From: Amanda Scholes on behalf of Planning.Responses
Sent: 20 October 2017 13:13
To: Planning Scanning
Subject: FW: Saltbox, Bognor Regis - Heads of Terms

Sent: 20 October 2017 11:35
To: Michael Eastham
Cc: Arfon Hughes
Subject: Re: Saltbox, Bognor Regis - Heads of Terms

In Nia's absence, there are just two design details that have arisen regarding the Unit 2 Warehouse:

2A: With Acoustic Barrier L_{Aeq}

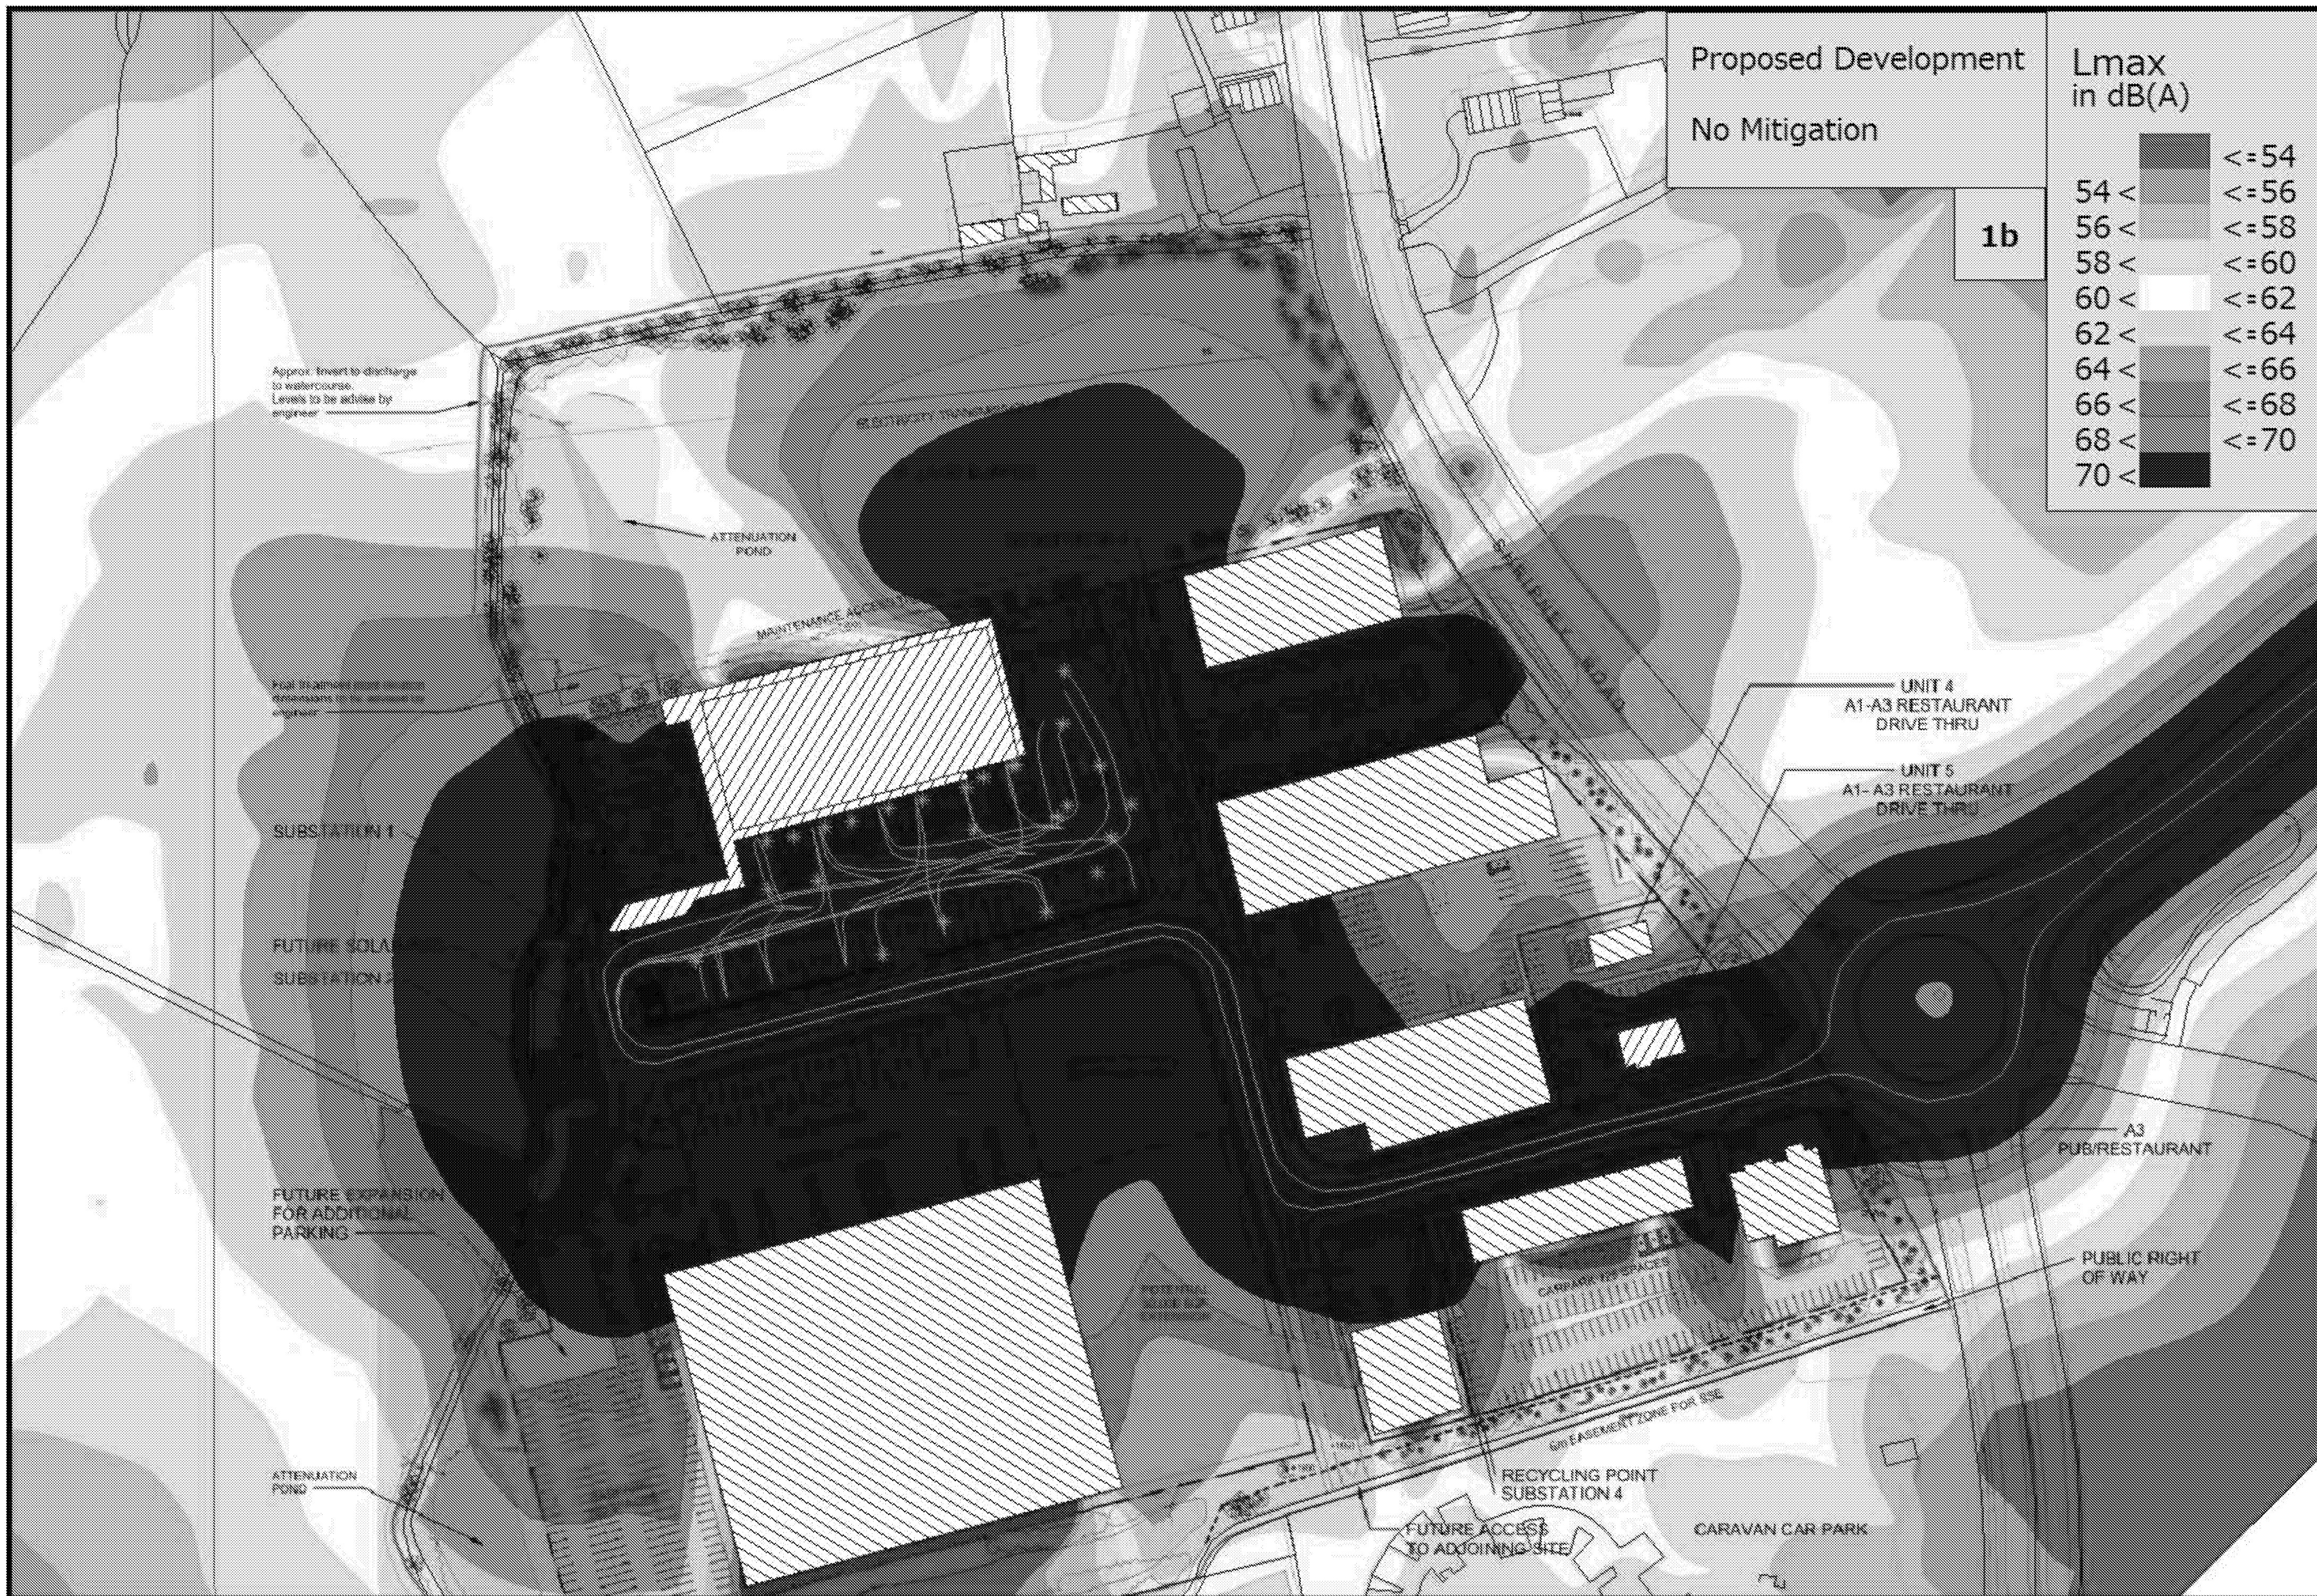
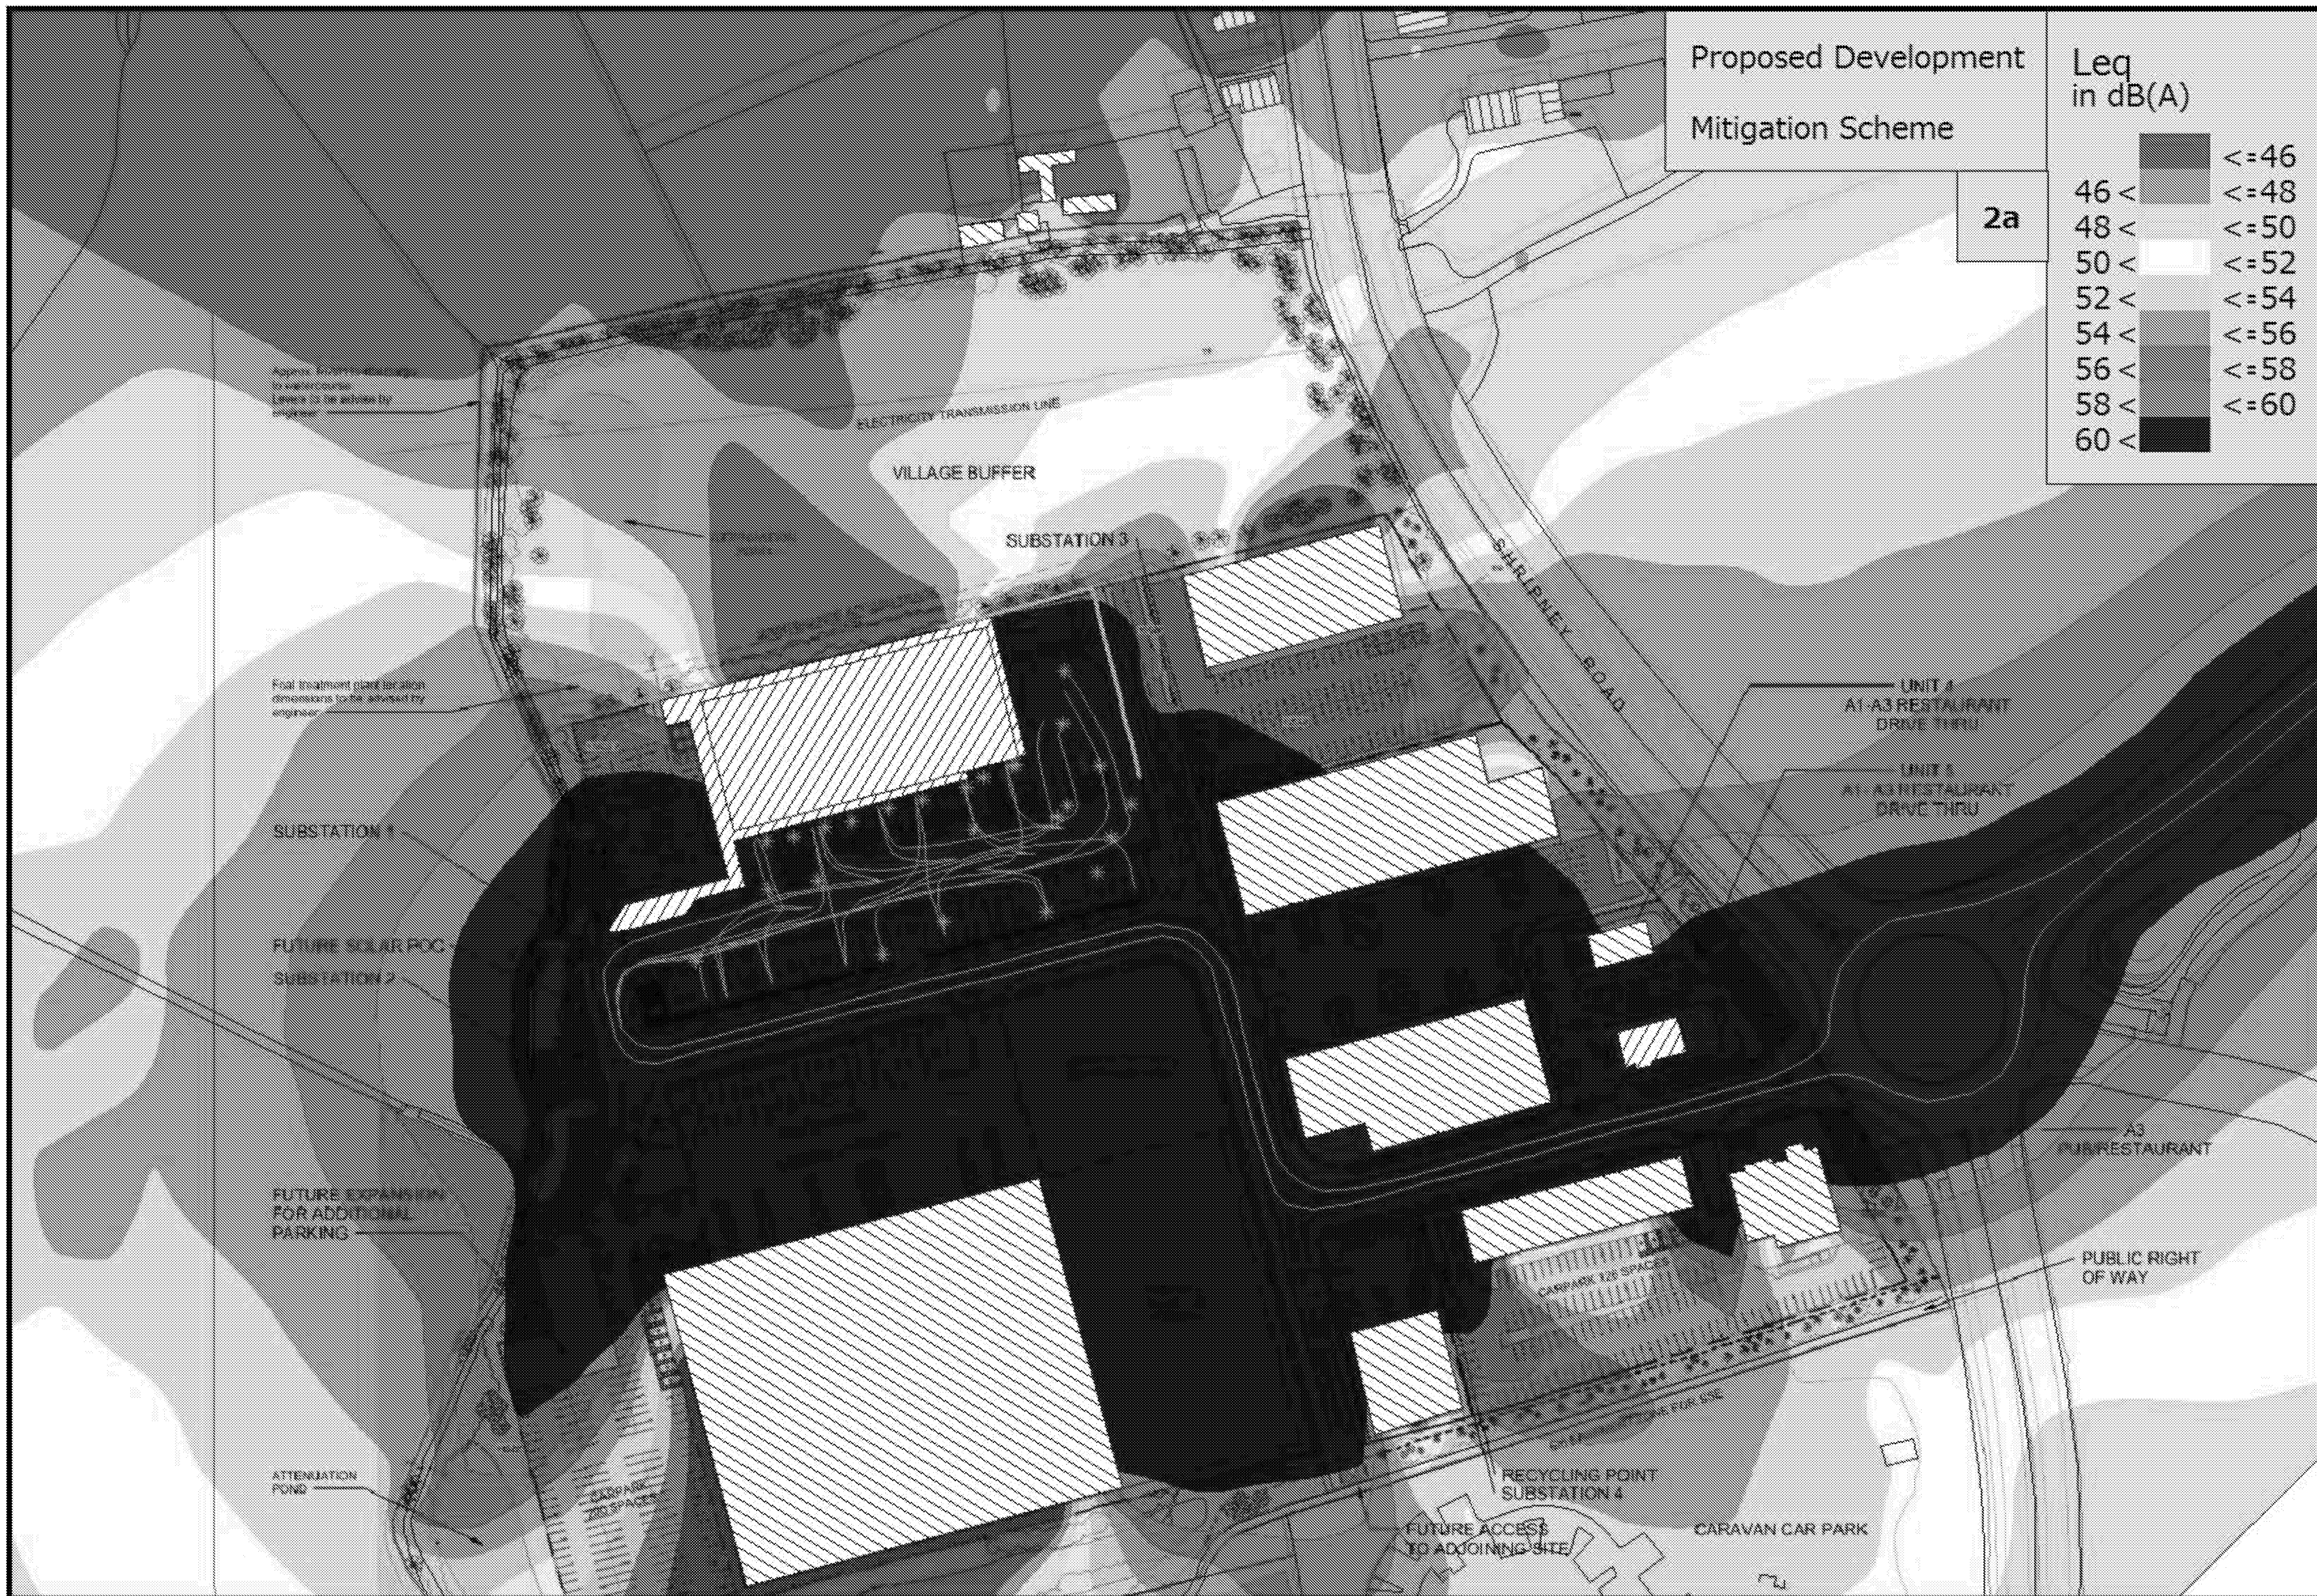
- 1) Does the Unit need to have security fencing (and gates) around it?
- 2) Does the acoustic fencing need to be 4.0 metres high? Could it be lower in height?

In relation to the acoustic fence, In the acoustic report, at item 4.24 the acoustic engineers state that to screen and protect sufficiently, the development requires a 4m high acoustic barrier formed with tanalised timber feather edged close board fencing. We have asked the engineers to re-run their model to explore if

there is potential for the height to be reduced and I will update you of the outcome of that exercise as soon as I am able to.
